20 December 2021

**Glenwood High School Upgrade (SSD-23512960)
Request for Submissions Report**

ATTACHMENT 1 – KEY ISSUES

Drawing Number
DA-LA-0002

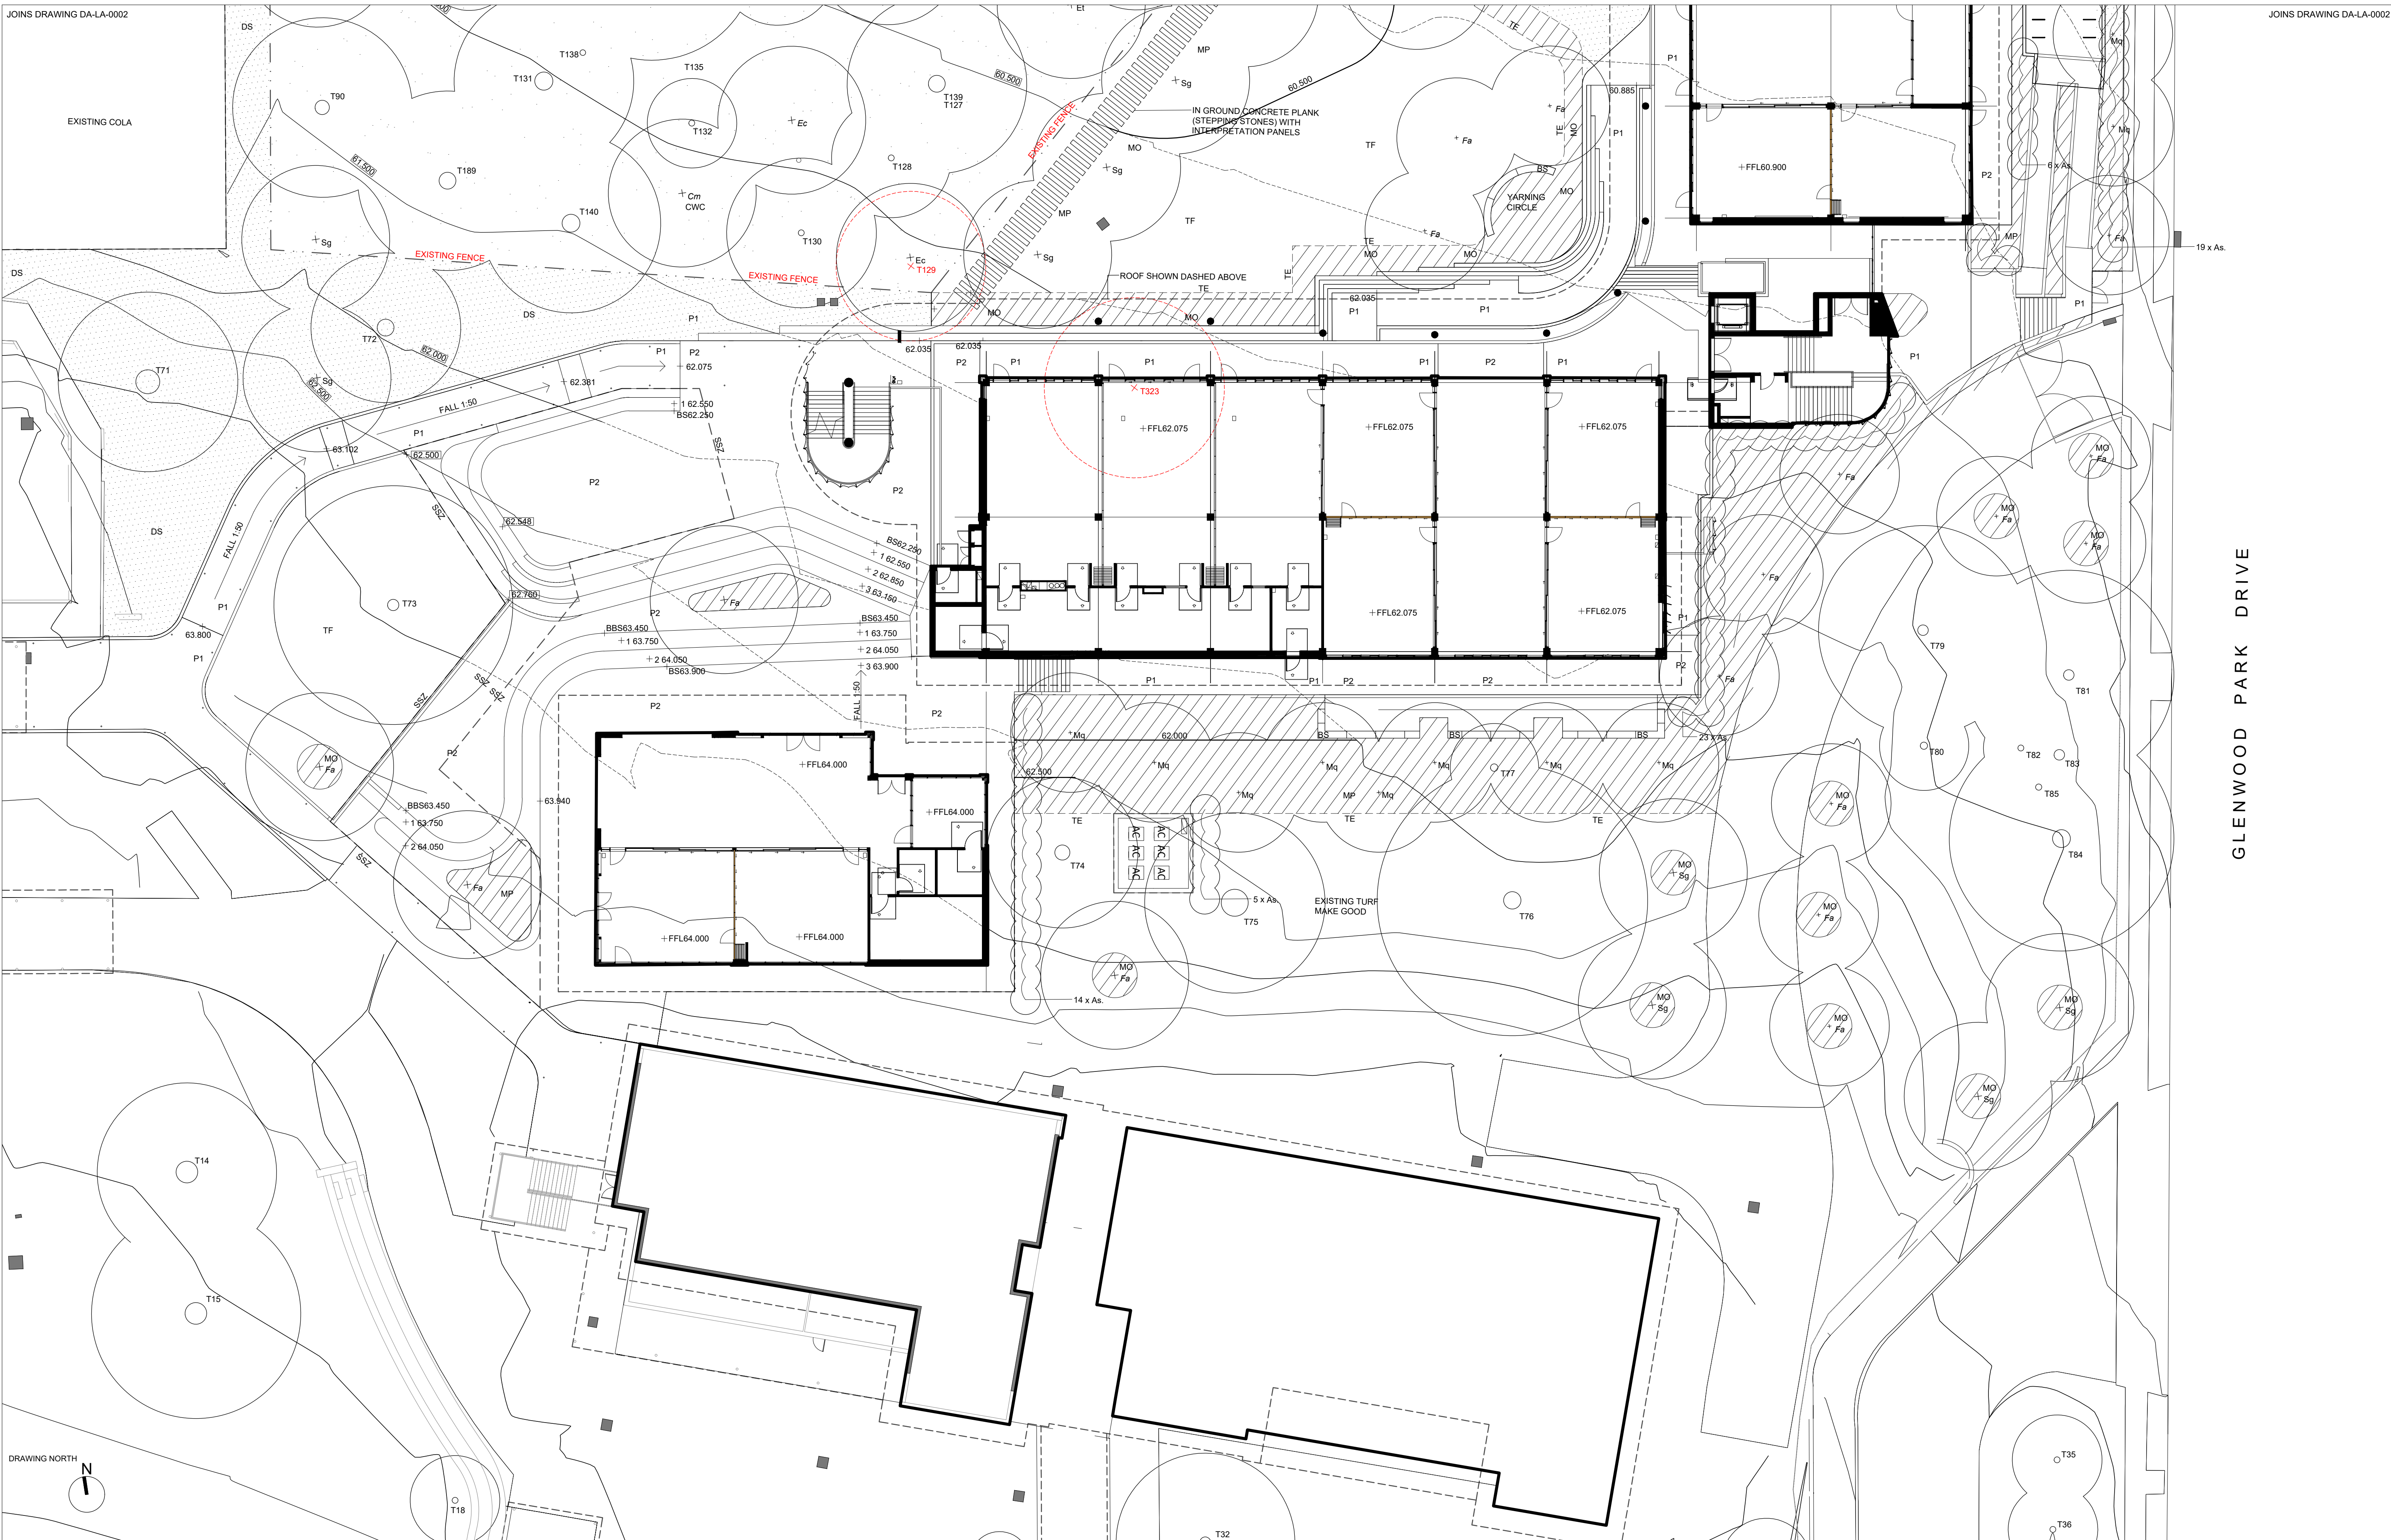
- The proposal includes the removal of a highly significant tree identified as Tree 73 in the submitted Arboricultural Impact Assessment (AIA). The AIA states that there may be possibility for design changes which could allow for the retention of this tree.
- Include further justification, evidence and assessment as to why a design modification cannot be achieved to provide for the retention of Tree 73.

Drawing Number**DA-LA-0003****Revision****F**

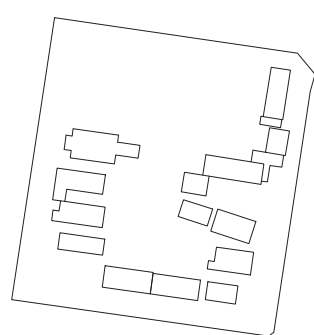
- Further address the State Design Review Panel (SDRP) advice for the project dated 14 December 2021, read together with SRDP 2 advice letter dated 13 October 2021, in particular advice relating to:
 - o Outline the reasons for the existing fence surrounding the Cumberland Plain Woodland is being retained which does not allow students to freely utilise the woodland area – if there are environmental reasons for doing so please identify.
 - o Why the site cannot provide a higher percentage of tree canopy coverage (40%)
 - o Identify and provide opportunities for the entire site to be able to benefit from additional tree plantings and not solely the area adjacent to the new buildings
 - o Why the footpath has not been reinstated forming a pedestrian connection between end points of the new 'L' shaped building.
